SPR EA1N and EA2 PROJECTS

DEADLINE 4 - COMMENTS ON APPLICANTS DEADLINE 3 SUBMISSIONS (TRAFFIC & TRANSPORT ISSUES)

Interested Party: SASES PINS Refs: 20024106 & 20024110

Date: 13 January 2021

Plate 1.1 Outline CTMP Governance Structure

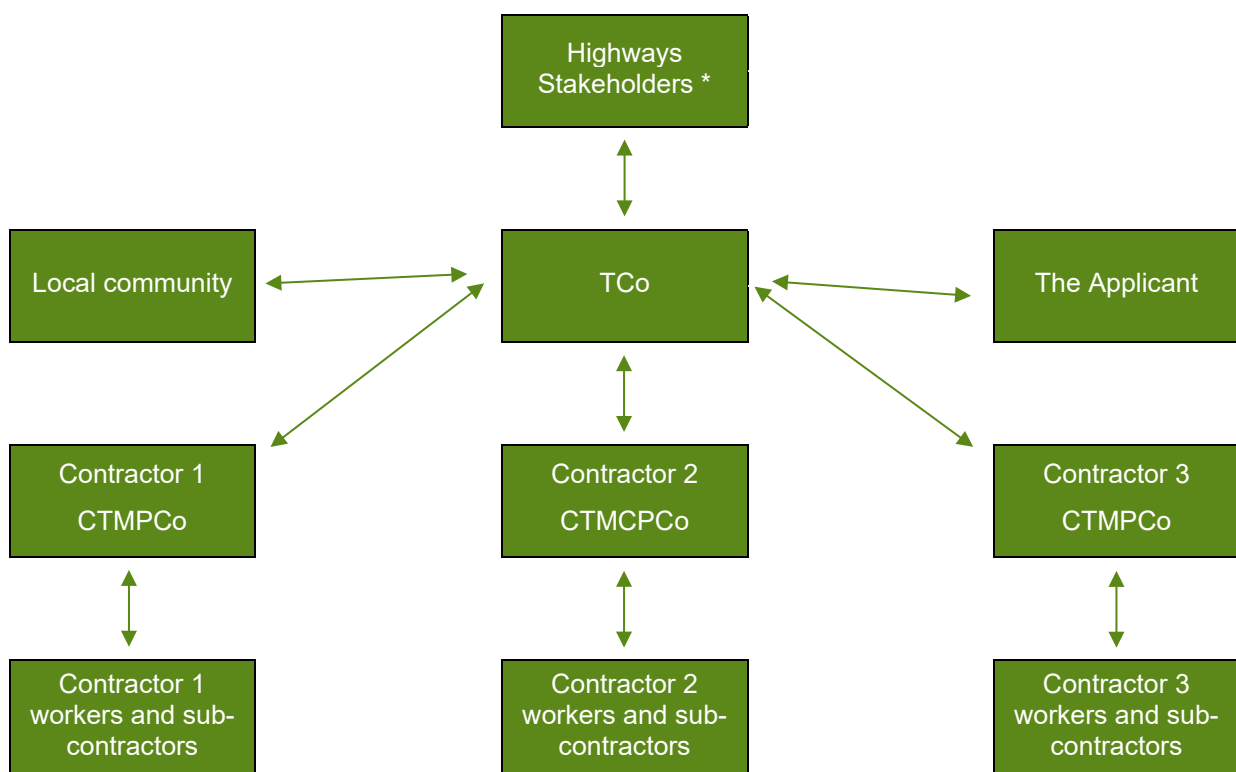
Para 19 Plate 1.1 indicates that the TCo (traffic coordinator) will be an intermediary between the local community, Parish Council and LAs (Highways) and SPR. This approach is considered to be a recipe for the dilution of local residents concerns.

Paras 16-19 The OTP envisages the existence of multiple contractors each appoint its own TPCo: this opens the door to multiple interpretations of travel policy, with Applicant acting as a “go between” Highways Stakeholders and Local Community and the plethora of contractors and sub-contractors. Plate 1.1 should make it clear that the Applicant is ultimately responsible for the activity of all contractors and sub-contractors in respect of vehicle movement.

DRAWING No.
TP-PB4842-DR007

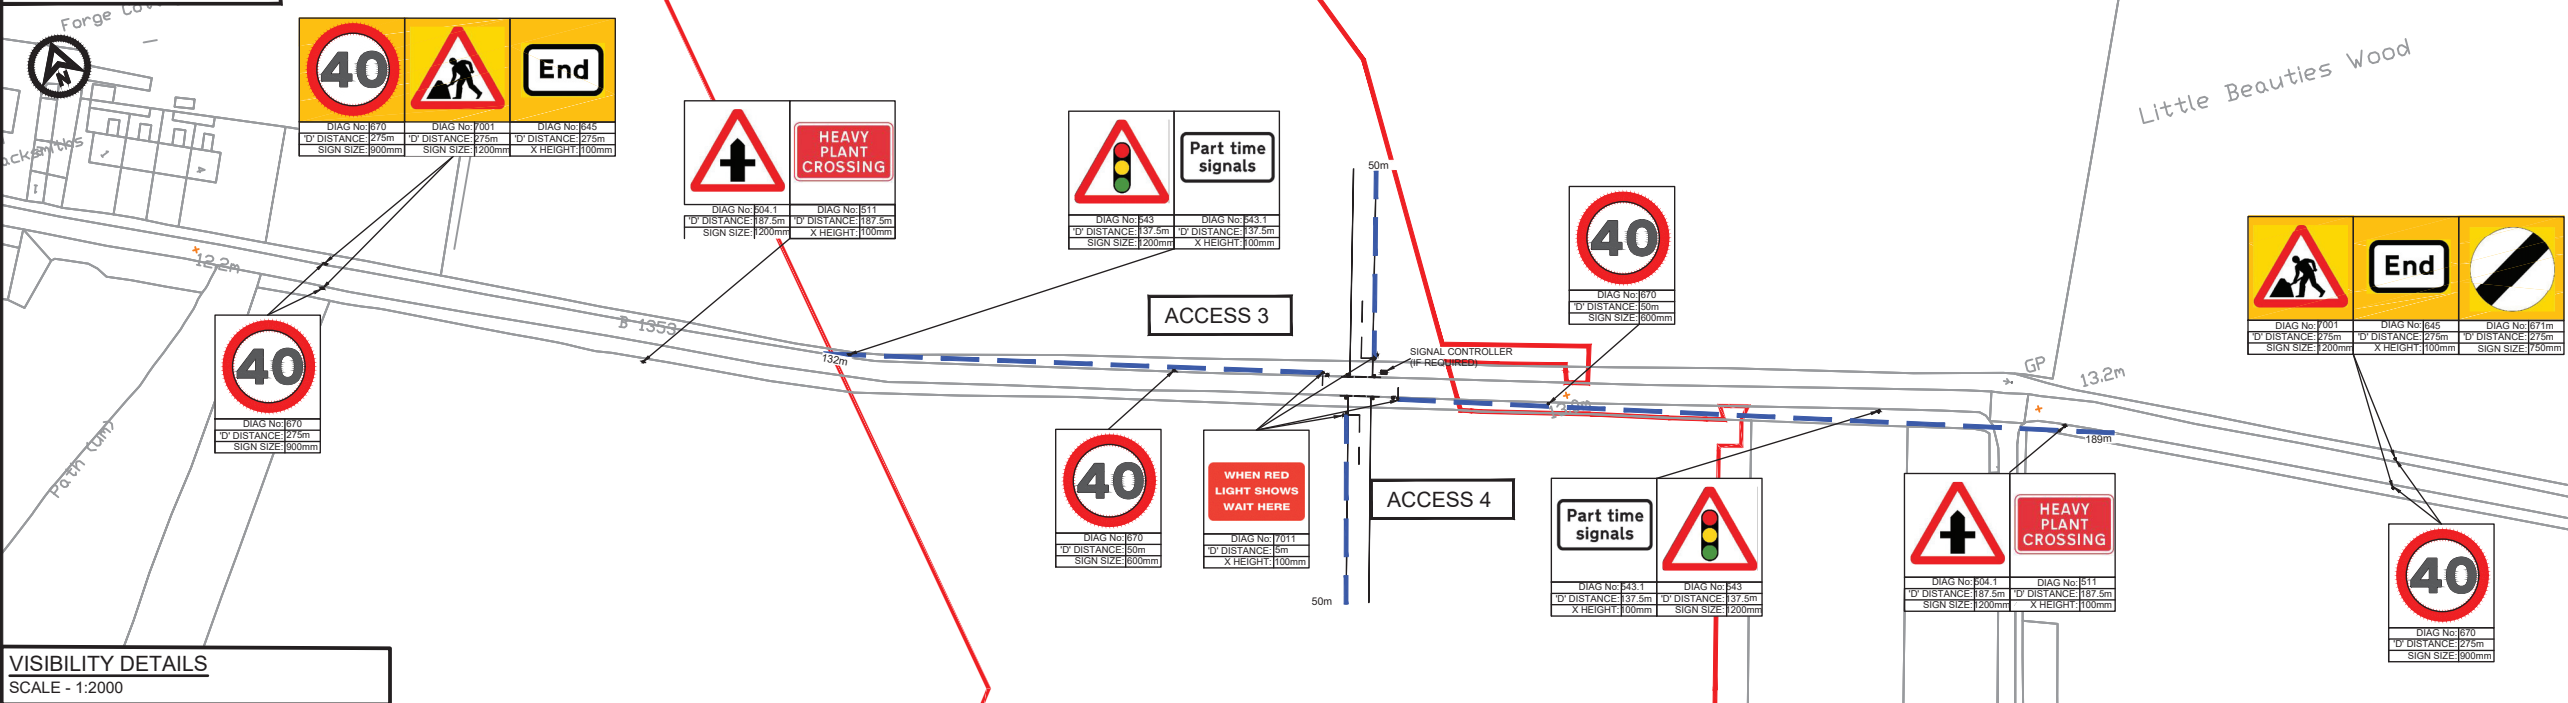
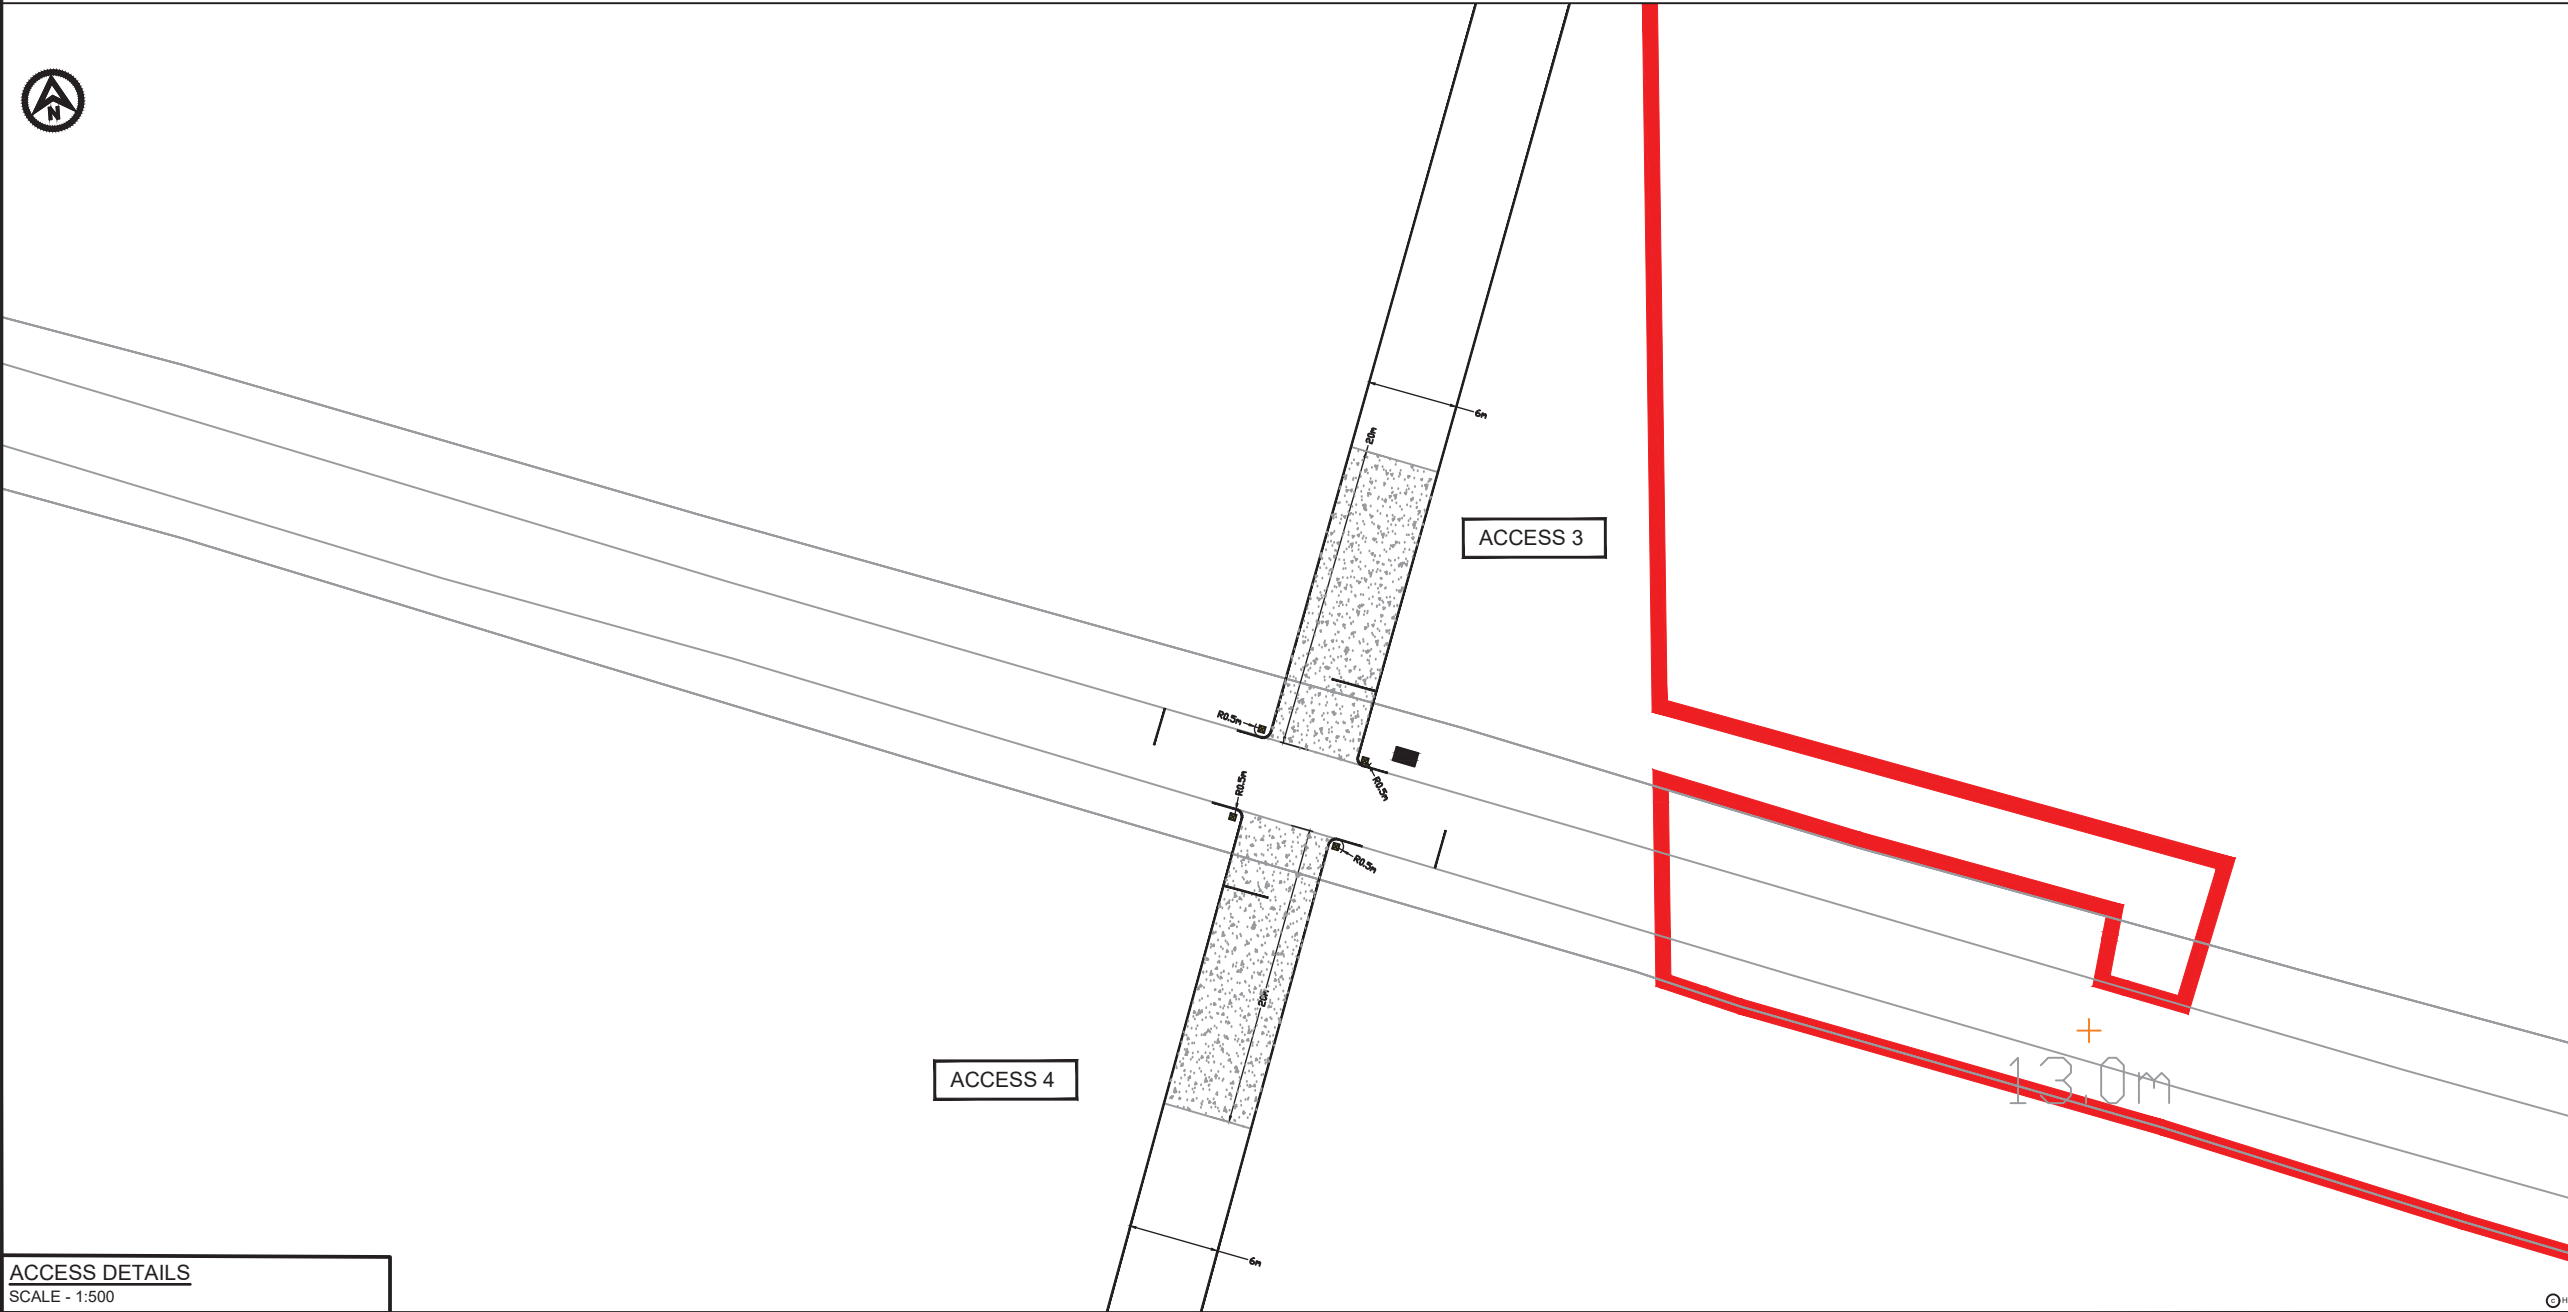
Appendix 2 Crossing 4/3	Drawing TP-PB4842-DR027 should make clear that this is not an “Access” but a crossing
Crossing8/7	Drawing TP-PB4842-DR007 should make clear that this is not an “Access” but a crossing
<i>Crossing</i> 11/12	Drawing TP-PB4842-DR014 should make clear that this is not an “Access” but a crossing
Access 13	<p>Why does drawing TP-PB4842-DR022 show swept path for a 6-wheeled HGV, no HGV are permitted access from the B1121 via either Sternfield or Friston and the drawing text box state: ..ACCESS 13 B1121 SAXMUNDHAM ROAD MAX ARTICULATED HGV SWEEP PATH ANALYSIS..</p> <p>Access 13 is described elsewhere IN SPR documentation as the intended access point to the substation complex for the AIL delivering the HVAC supergrid transformers. Why then does the drawing not show the impact of the swept areas for a multi-axle low-loader delivery</p>

B1121 - ACCESS 13
SCALE - 1:200

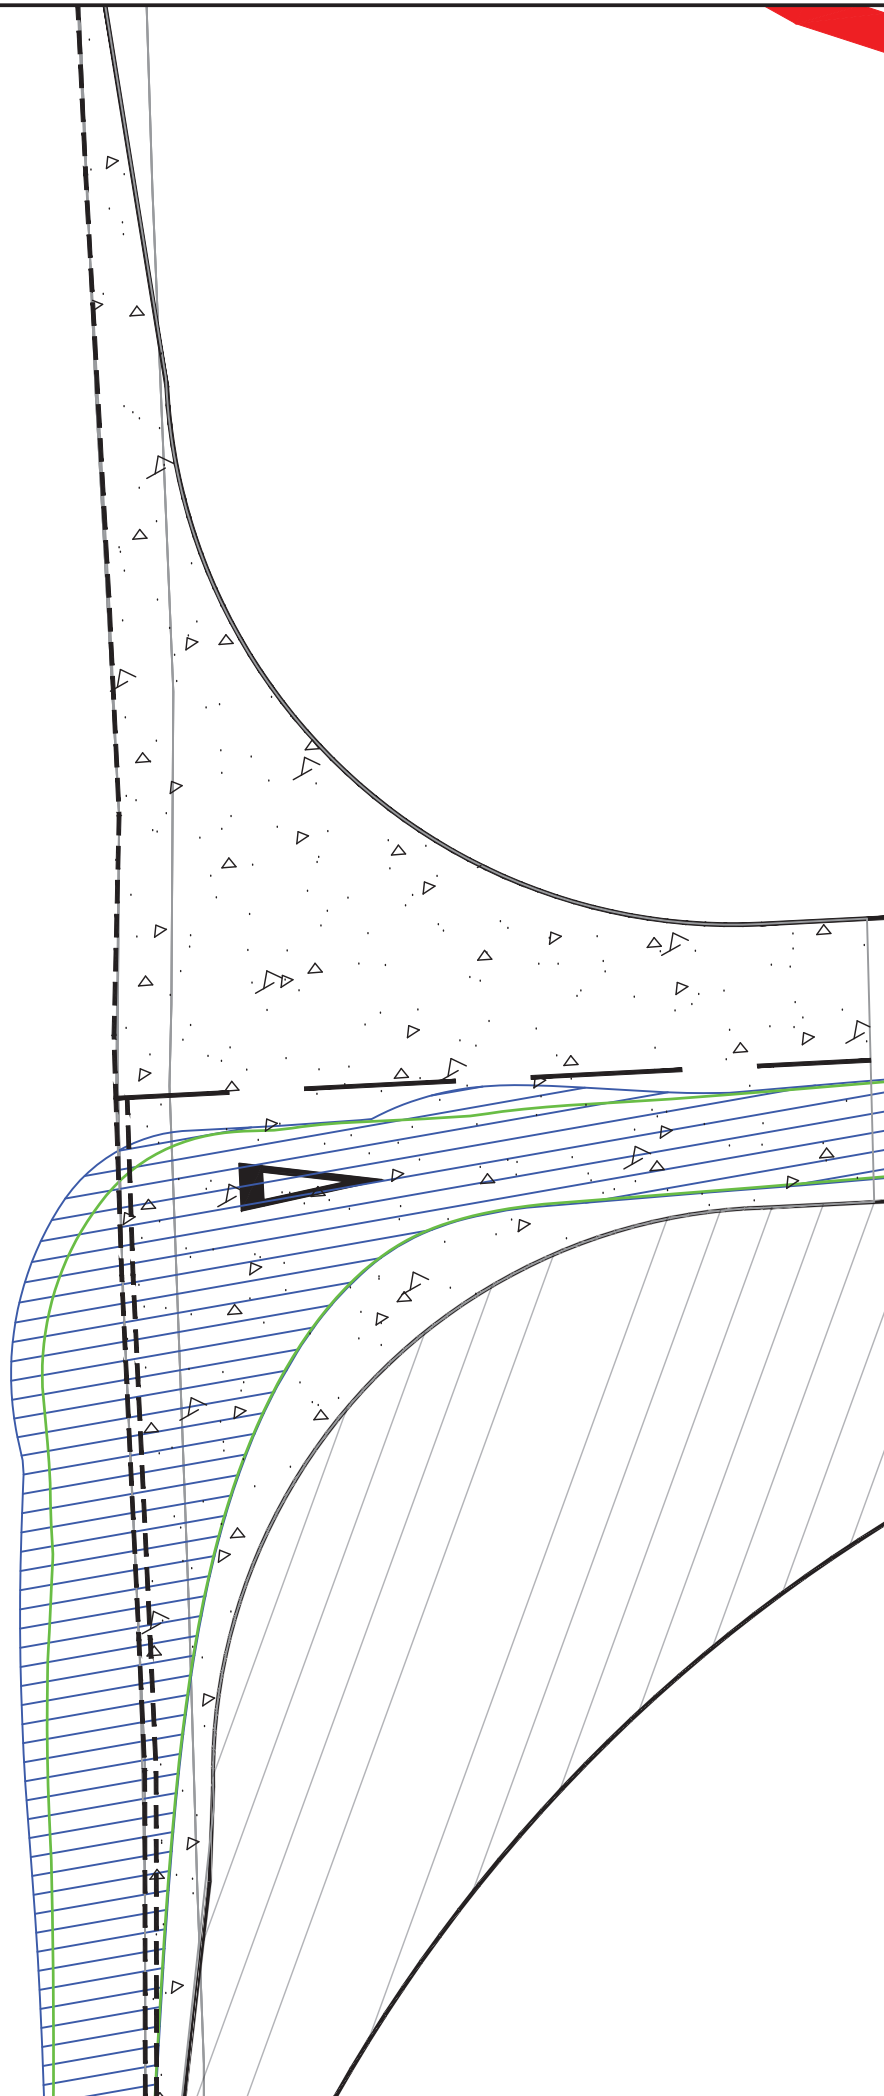
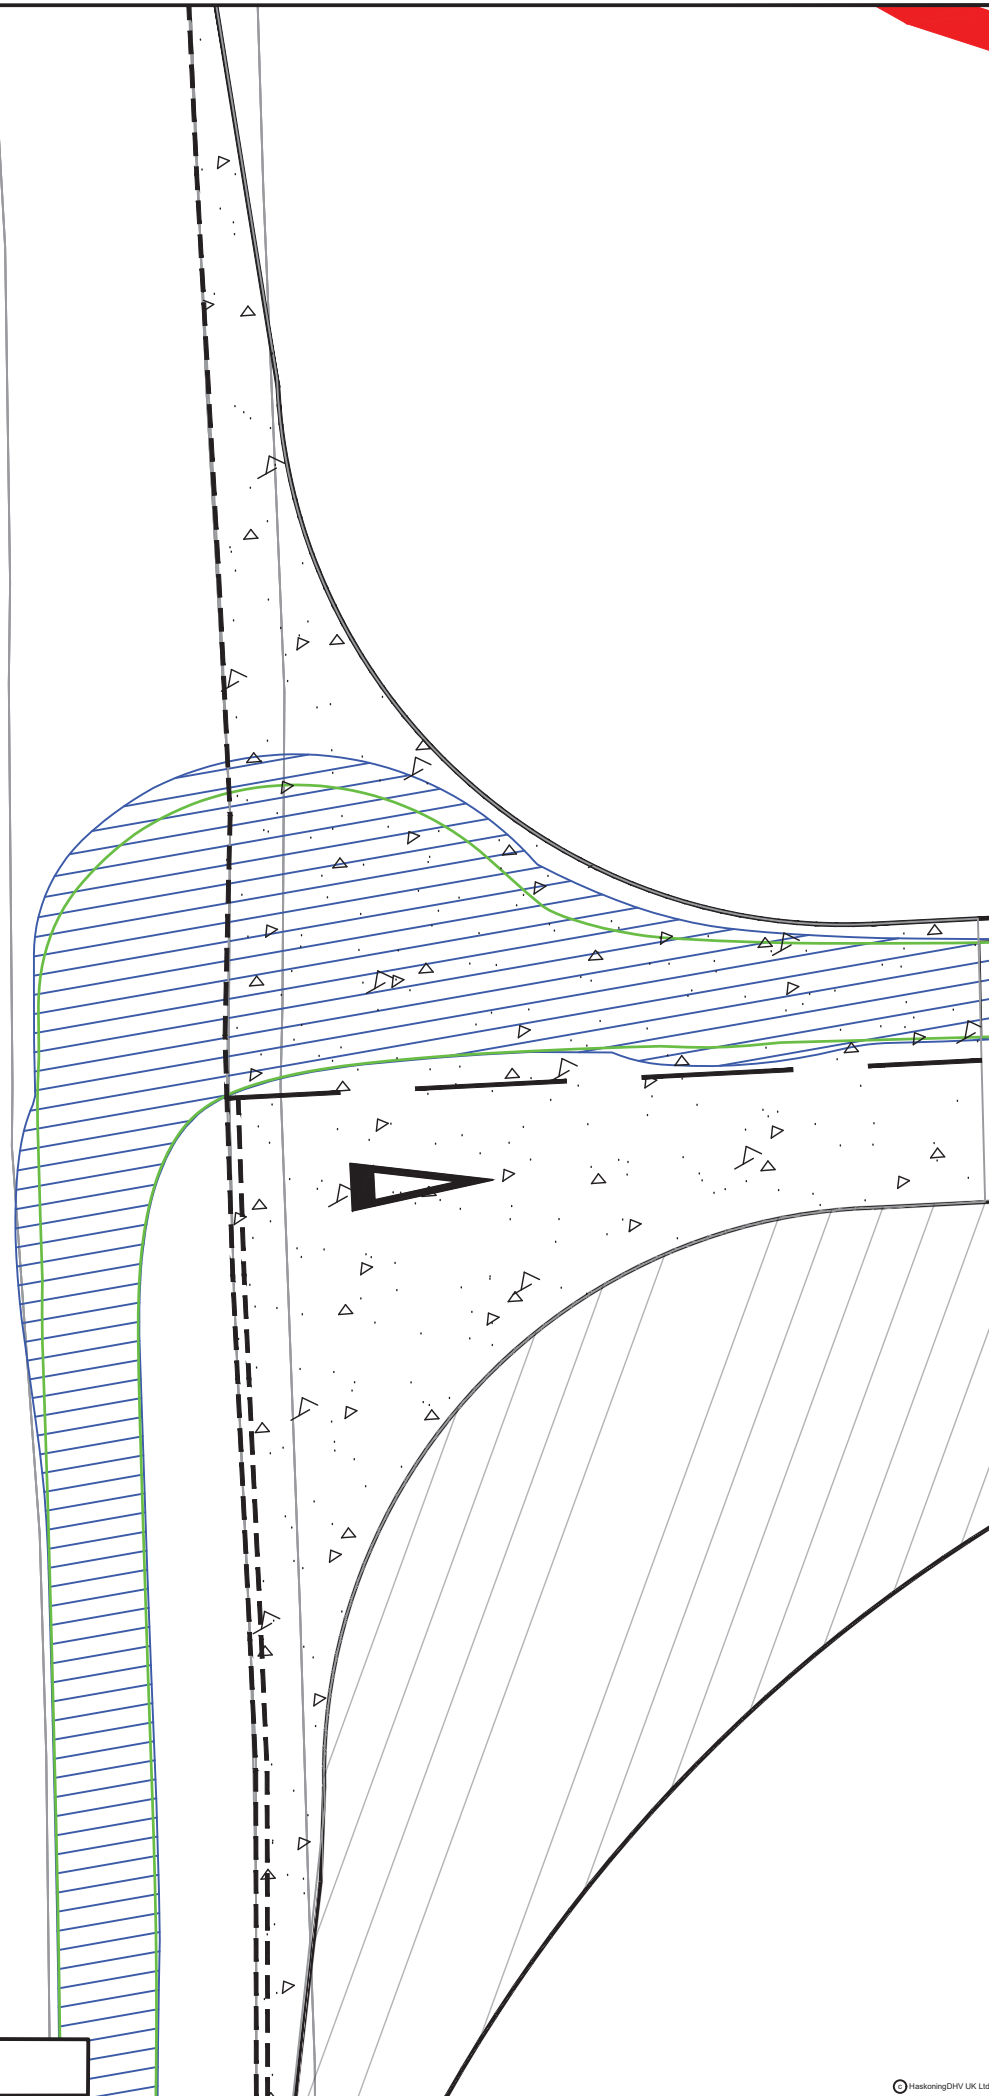
Para 31 The OCTMP Indicates that all HGV construction traffic will enter the substation and NG sites via Access 10, yet drawing in the Outline Access Management Plan (OAMP) [Reference SPR Document 8.10 IBR – 00944] shows the splay at Access 13 is sized to accept a 6-axle HGV. [See– Plate TP4842-DR022].

Annex 1 – Plate TP PB4824 DR 022 shows clearly that the splay at Access13 has been sized on the basis of the largest category HGV, (six -axle, 44 tonnes GLW). This again contradicts statements made in paras 15 and 16 above.

The diagram clearly shows an HGV heading in the direction of Sternfield suggesting that the Applicant has always envisaged HGVs entering/leaving the site from the B 1121 via Sternfield
